Planning Application Ref: AW/108/17/T

Location : Wychwood House, 1 Wychwood Walk, Aldwick

Description of works: Fell 1 No. Oak tree

REFERENCE T.3.

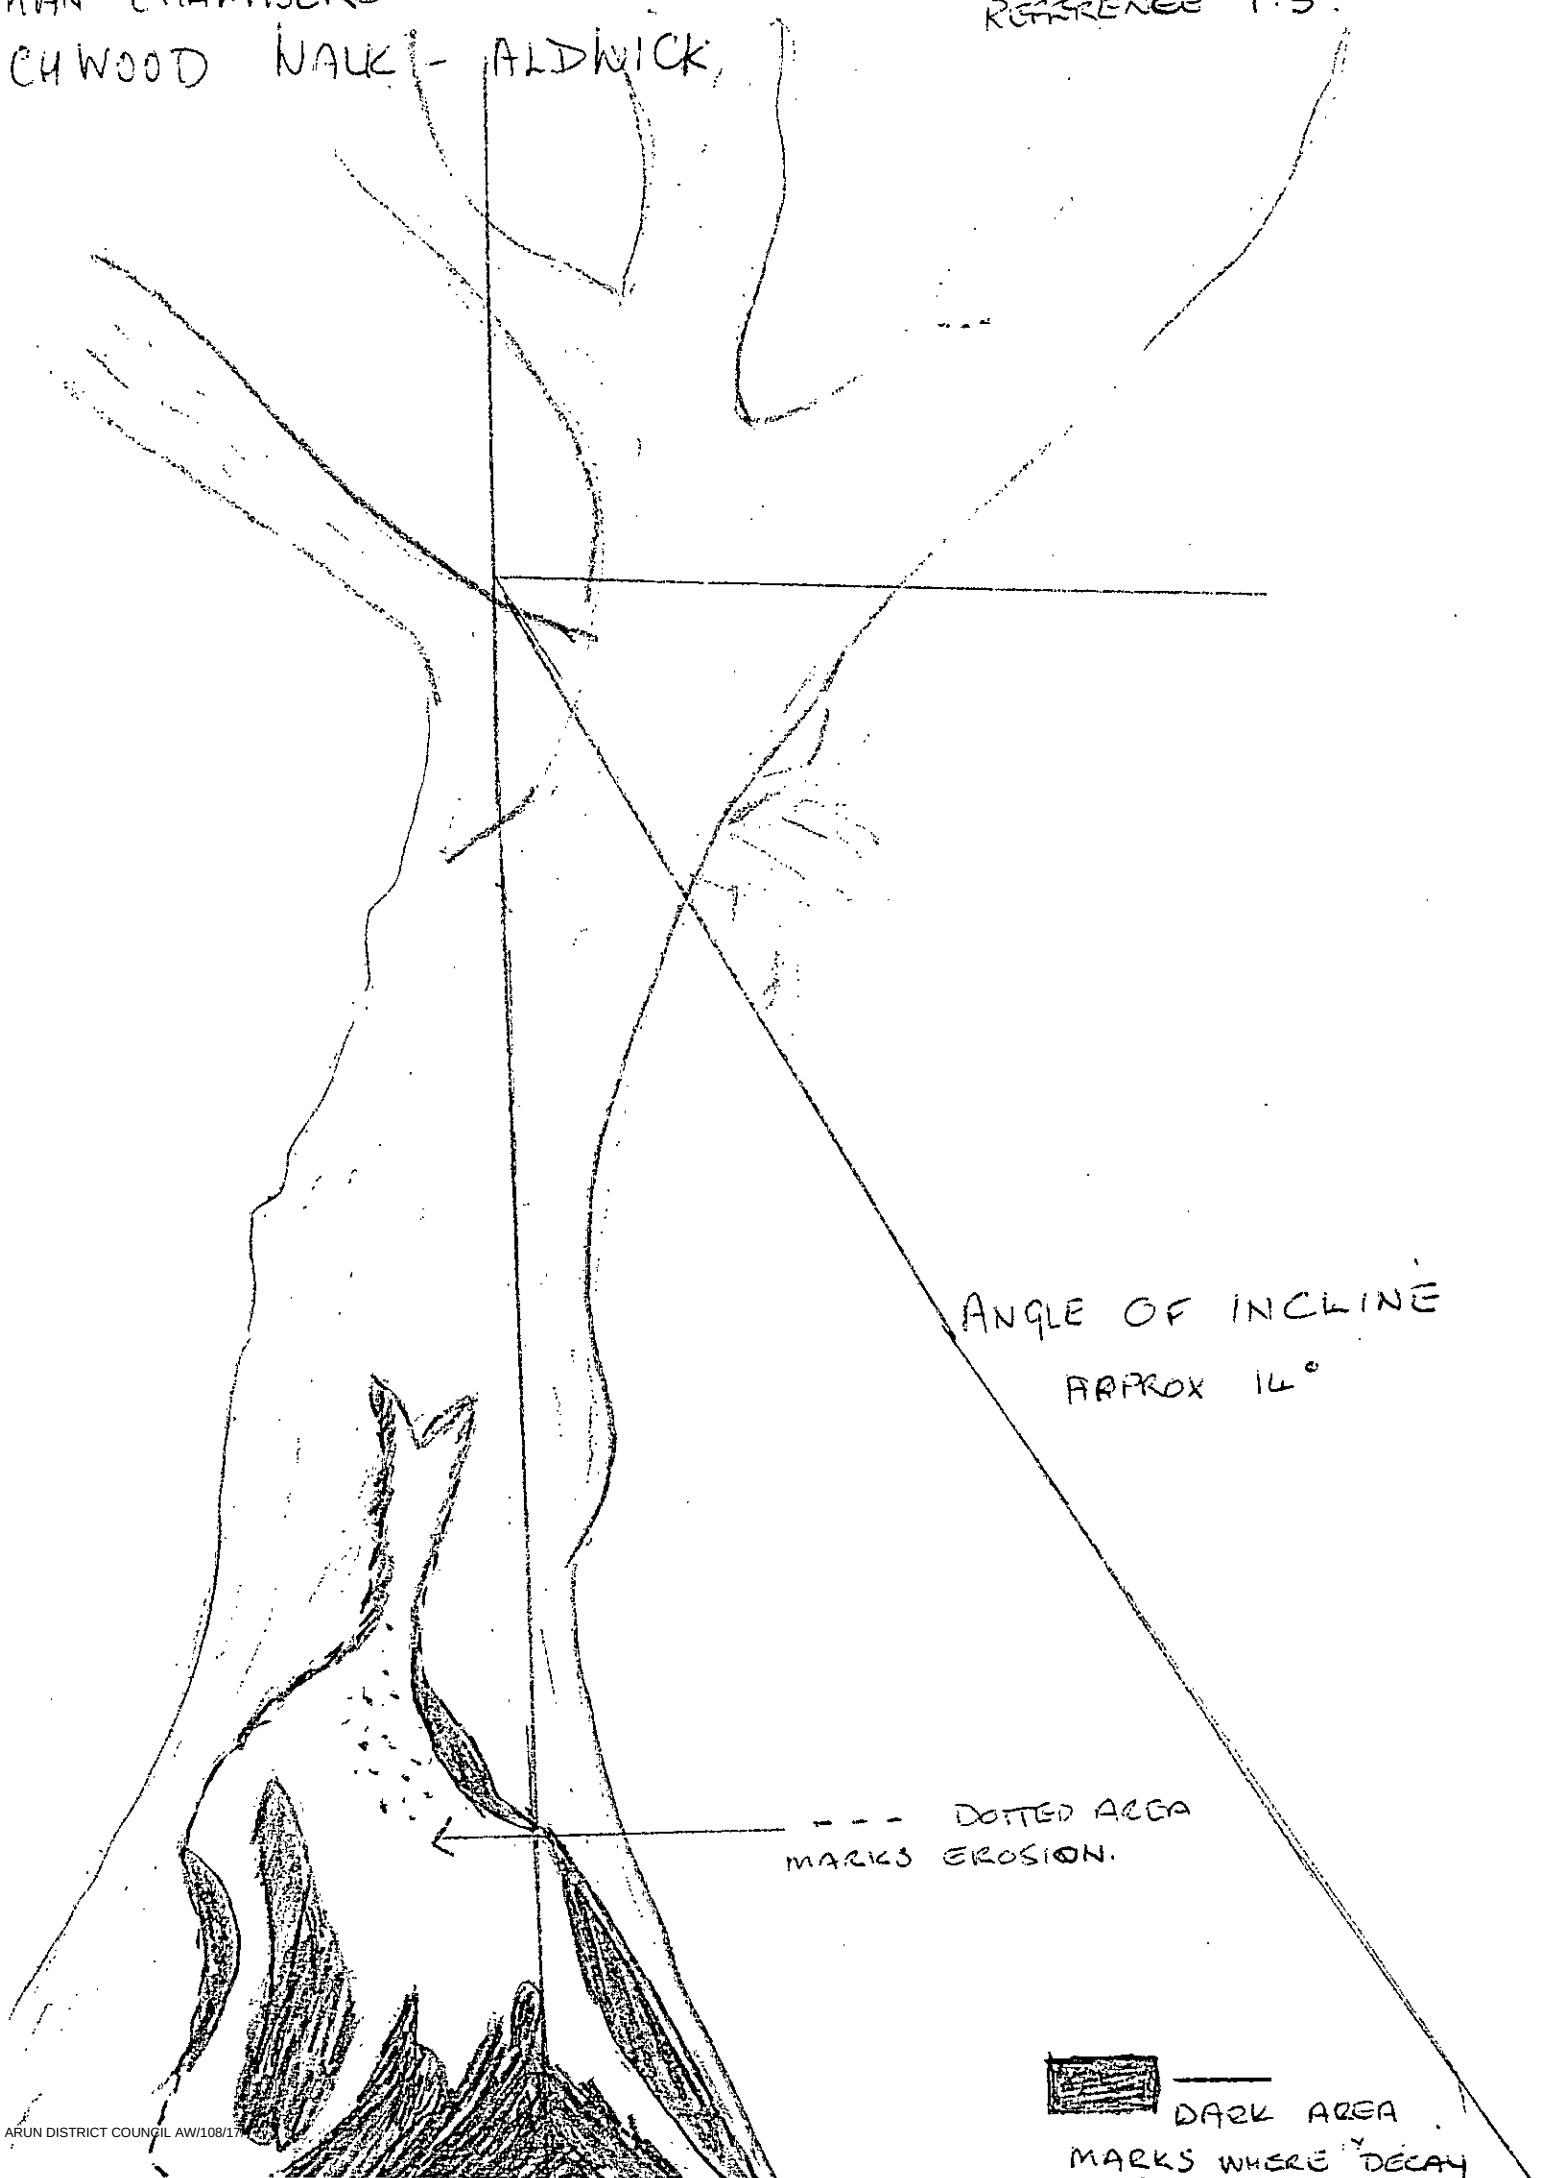
- I inspected this tree and probed behind the bark wounding on the house side of the tree at ground level but there was no real depth to the decay (70-100mm in a few small localised places but otherwise 20mm around edges of visible wound).
- The wound extends up the trunk to 0.5m and is around 300mm wide and the exterior is for the most part solid – being an Oak this is a strong and durable species well able to cope with such injury - this is a superficial wound that does not undermine health or stability.
- There is a natural lean to the tree but again being an Oak I am not overly concerned about this.
- The crown is full and healthy with normal leaf size and good lustre - having regrown following on from a previous reduction exercise.

- This tree is currently sound and healthy and its stability has not been compromised by the noted minor level of decay in the trunk.

- I recommend **REFUSAL** of this application seeking the felling of this tree as there are insufficient grounds to justify such action and it is a much valued tree in the landscape.

- If the applicant chooses to come back in with a maximum 2m crown reduction exercise then I would be minded to approve this course of action.
